**Re: Carlisle Blvd. & Menaul Blvd. Commercial Development Subdivision  
3535 Menaul Blvd. NE  
Erosion and Sediment Control Plan (SWQ-2026-00012)  
Engineer's Stamp Date – 2/9/26 – H16E083F**

Based on the information in your submittal received on 2/12/26, the ESC Plan cannot be approved for Subdivision and Work Order until the following comments are addressed.

**SHEET:
2 - SWPPP
NOTES**

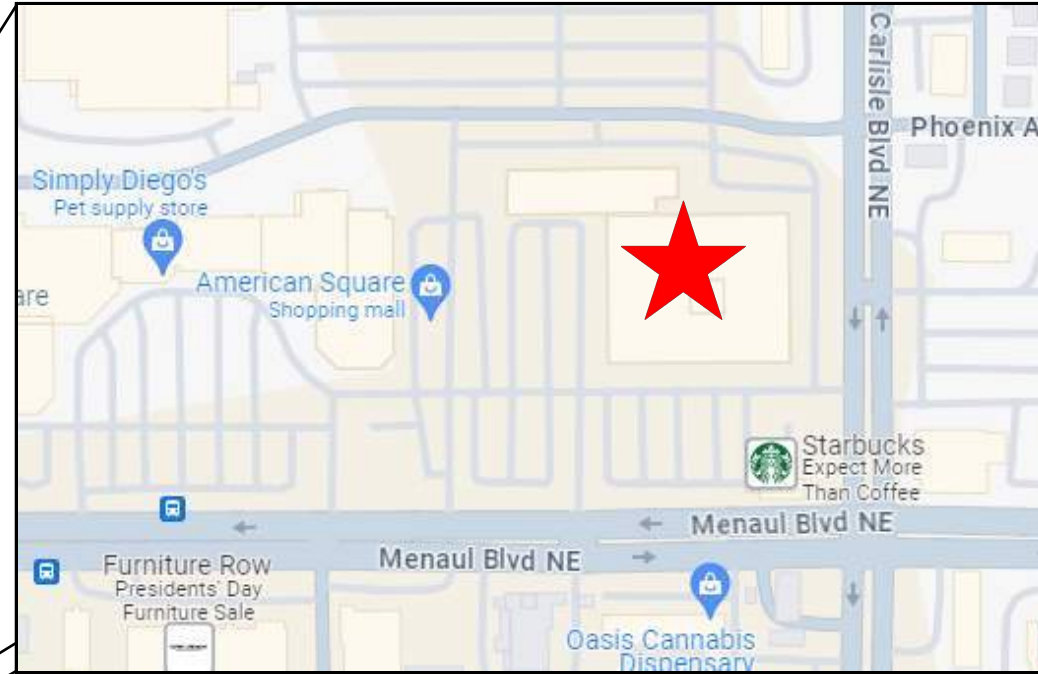
3. The sequence of activities on sheet 2 of the ESC Plan is inconsistent with the scope of this project and with the requirements of the EPA’s CGP. Please correct the sequence to include notes as follows.

- a. Since the entire site is already disturbed and enclosed by construction fencing, note 1 of phase 1 should be revised to read *“Phase 1 of this project began in May 2024, including the sediment traps and other BMPs as shown on the ESC Plan, with the engineer’s stamp dated 4/26/2024. Activities included demolition of the pre-existing building and parking lots.”* The Phase 1 ESC Plan is already in the SWPPP and doesn’t need to be included in this new submittal to the city.

- b. Phase 2 of this project begins with the completion of the BMPs identified in note 2 of Phase 1, so move that note to Phase 2 and add the following note: *“Phase 2 activities include construction of the temporary sediment traps, and diversion channels during initial grading activities, the construction of public utilities, and paving of shared access driveways. No fill or grading is allowed in the Phase 1 sediment traps until the Phase 2 controls on lots 2, 3, and 4 have been constructed and made operational. The Phase 2 grading, construction, and controls are shown on sheet 8 of this ESC Plan.”*

- c. The first note of Phase 3 is acceptable, where it says, *“If vertical construction does not begin within 14 days of ceasing earth disturbing activities, the disturbed area will be temporarily stabilized.”* However, notes 2 and 3 are problematic and should be replaced with a note saying, *“Phase 3 of this project includes stabilization and BMP maintenance on lots still owned by Vista Oriente, LTD. Co. as shown on sheet 9. After the phase 2 paving is complete, the perimeter fencing and controls should be adjusted to enclose the lots still owned by Vista Oriente, LTD. Co. The fencing and controls should be revised to exclude lots when they are sold to new operators. The Phase 3 temporary and permanent stabilization construction specifications are also shown on sheet 9.”*

- d. *Phase 4 involves constructing commercial buildings, parking lots, and landscaping on individual lots. Activities and controls for Phase 4 are not shown on this ESC Plan. Separate ESC Plans must be approved by the city for each lot before a building permit is issued. Lots developed by Vista Oriente, Ltd. Co. do not require a new NOI, and the ESC Plan for the building permit can be added to the subdivision SWPPP once approved by the city. A new NOI and ESC Plan are needed for any lots sold to a new owner at least 14 days before the transfer of control, and the transfer date must be indicated on Vista Oriente, Ltd. Co.’s SWPPP map (ESC Plan sheet 9) for the subdivision. Construction fencing and perimeter controls should be removed sold lots. **Vista Oriente, Ltd. Co. must follow the CGP requirements until it has developed and stabilized its property and transferred all remaining undeveloped lots to new owners with separate CGP coverage.”***

SHEET:
3 - GENERAL NOTES

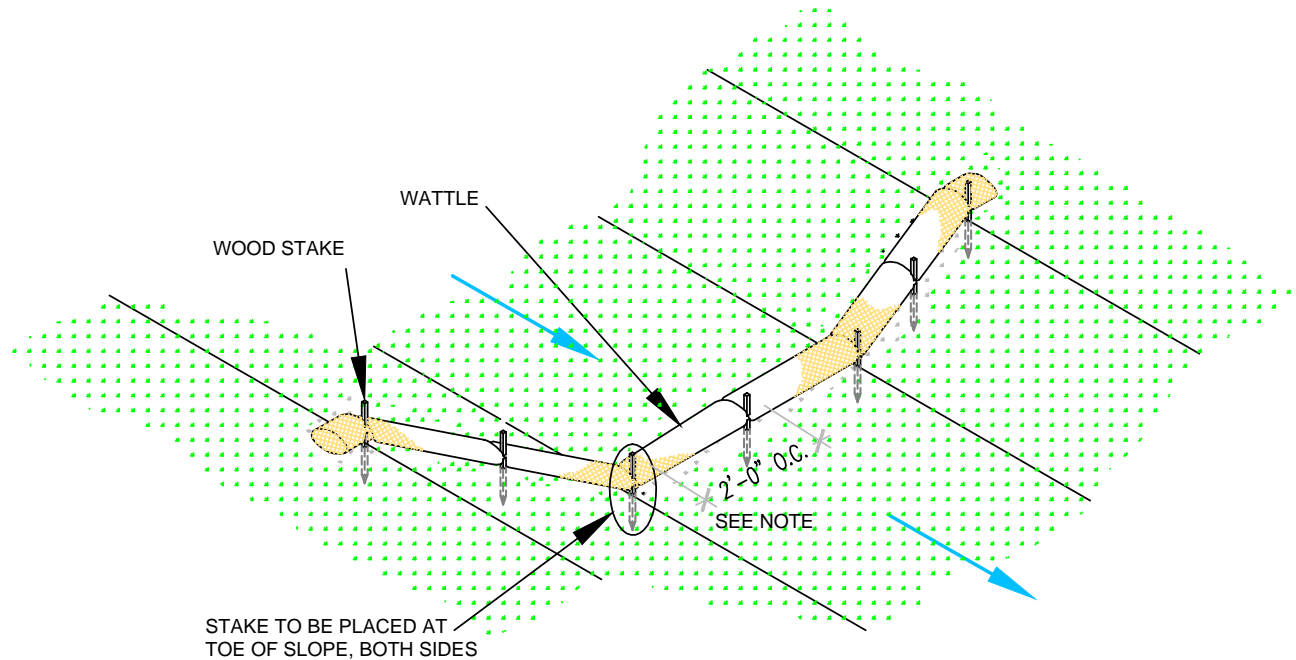
4. Replace the city standard notes on sheet 3 with the current version (attached). Add city BMP details for Stormwater Silt Fence (SWSF), Compost Filter Sock (CFS), Sediment Trap (ST), Construction Exit (CE), and Diversion Channel (DC) on sheets 4 through 7 to better comply with the NMED requirements in CGP 9.6.1.c.i where it says paraphrased, *“the SWPPP must also describe design specifications, construction specifications, maintenance schedules, and criteria for inspections of the BMPs.”*

7

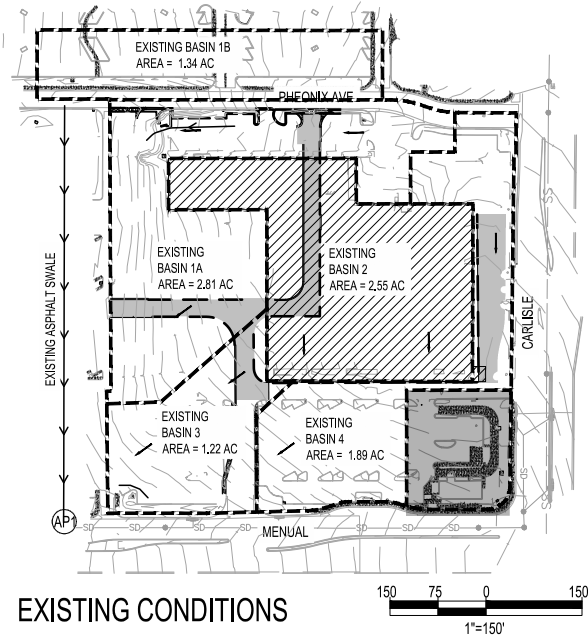
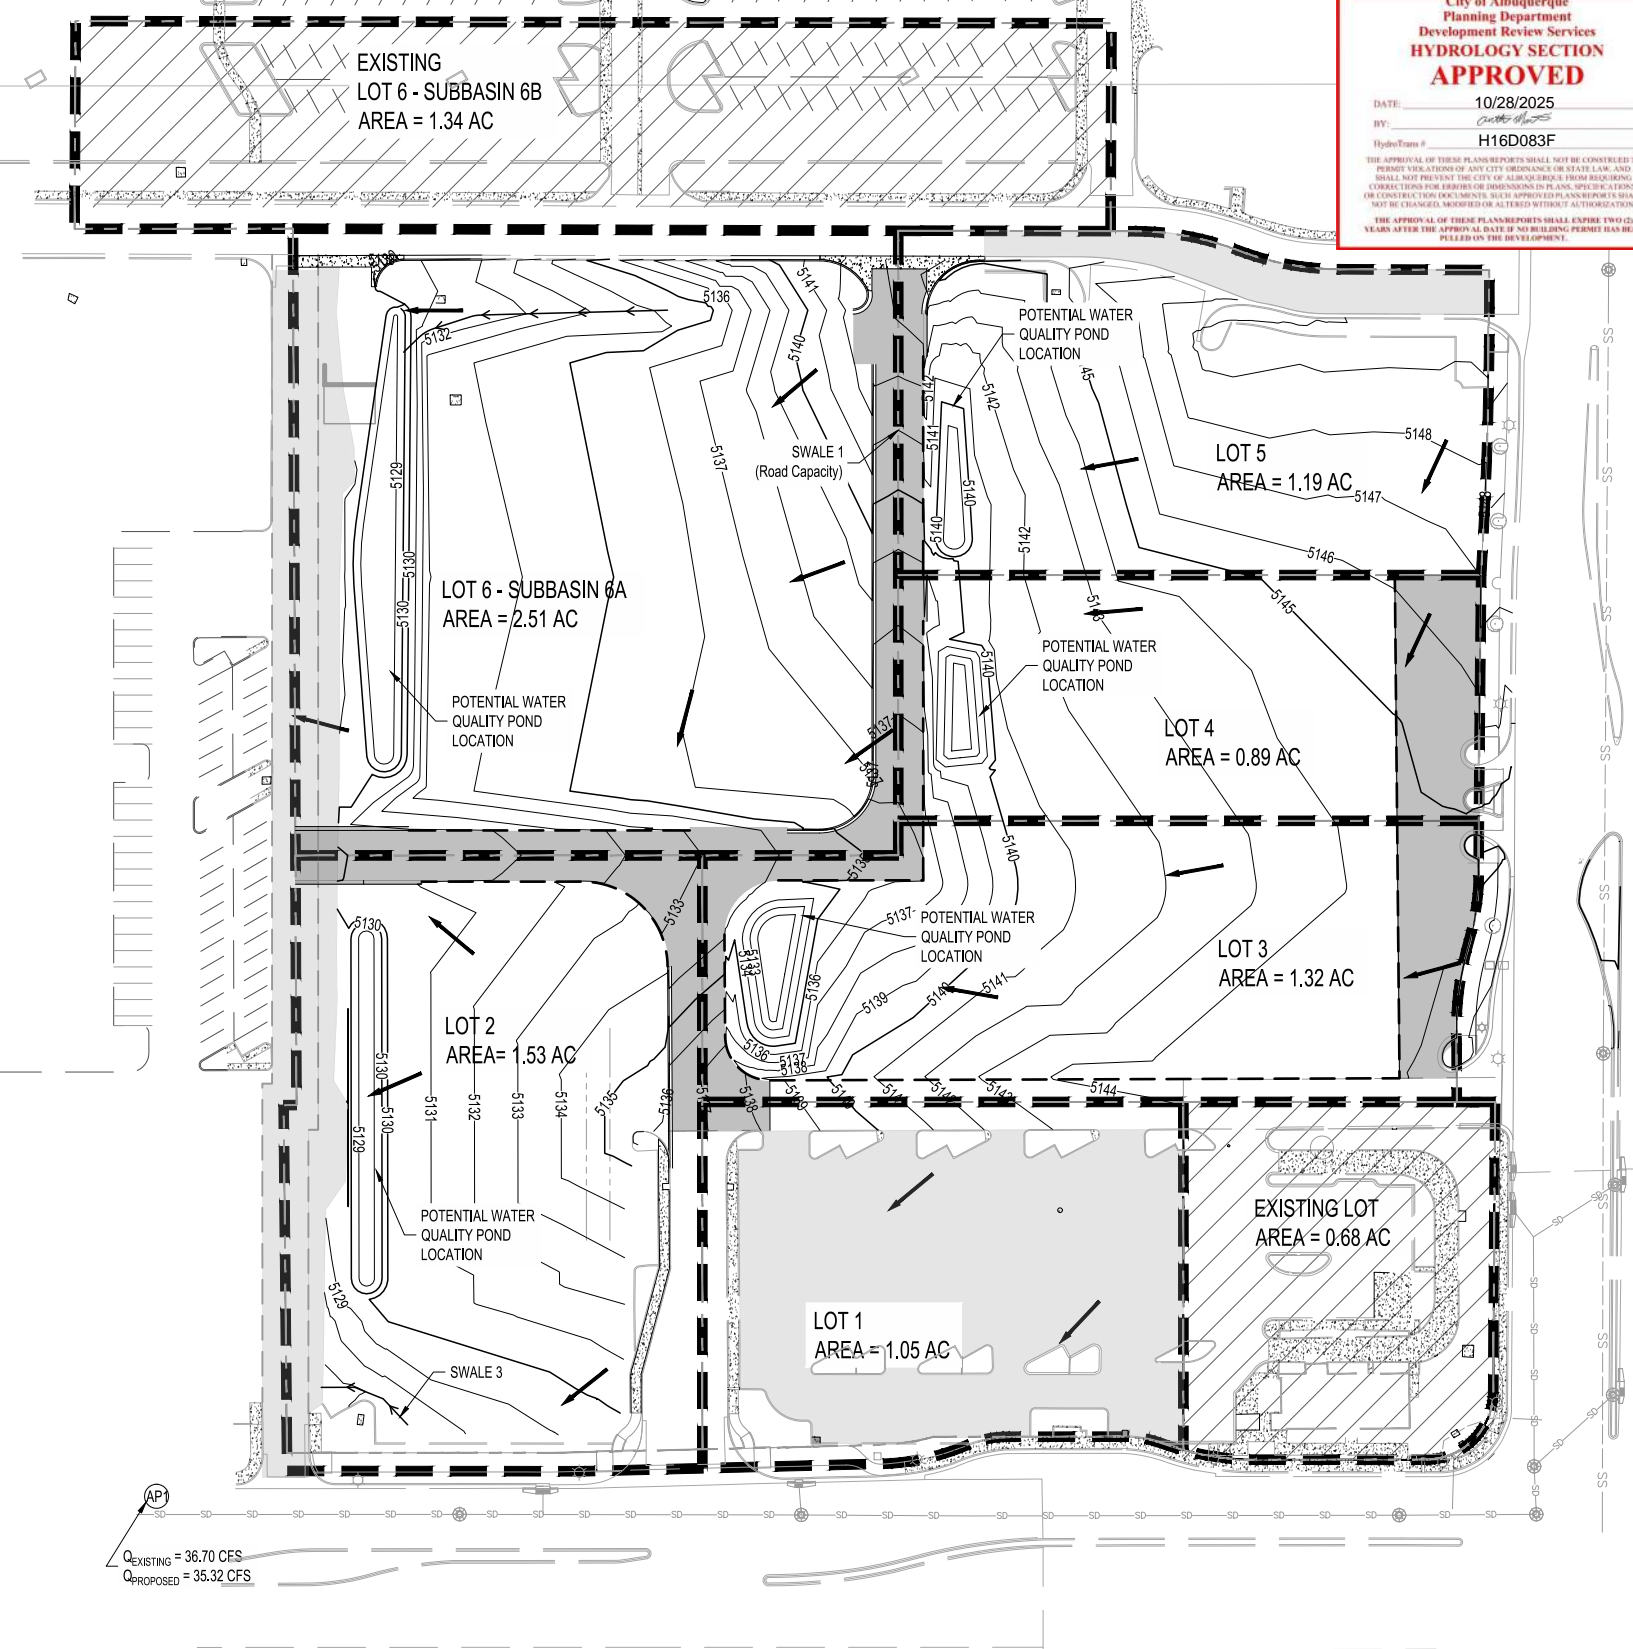
6. Sheet 8 of the ESC Plan shows proposed, Phase 2, subdivision grading with stormwater controls, including new sediment traps and perimeter controls. Label this sheet as Phase 2. Also, add Diversion Channels (DC) on the downhill side of each lot, where necessary, to direct stormwater into each sediment trap, preventing cross-lot drainage and runoff into paved streets. A DC should be included in Phase 2 to divert drainage in the common access roadway at the west boundary into the sediment traps (STs) until the entire roadway is paved. Sheet 9 should show the same controls as sheet 8, except for the DC in the common access roadway at the west boundary.
